Application for a Non-Material Amendment Following a Grant of Planning Permission

The Vale

Erection of a single storey extension to the rear

24428/APP/2023/1344

3 Proposed Rear Elevation
1 : 50

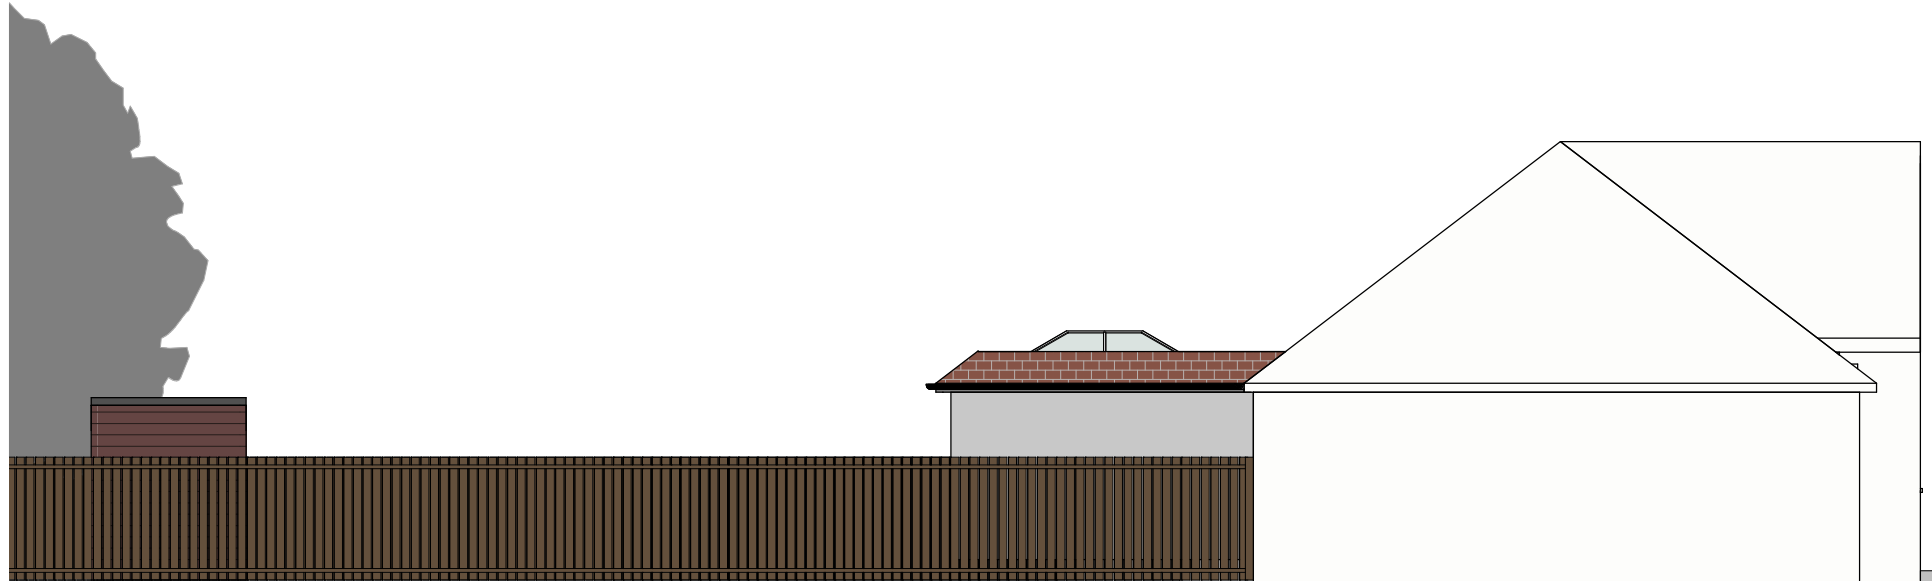
We wish to add the rear window to gain more light and ventilation in the kitchen area

PN-001 Rev 2.0 to PN- 014 Rev 2.0 dated 28.07.23
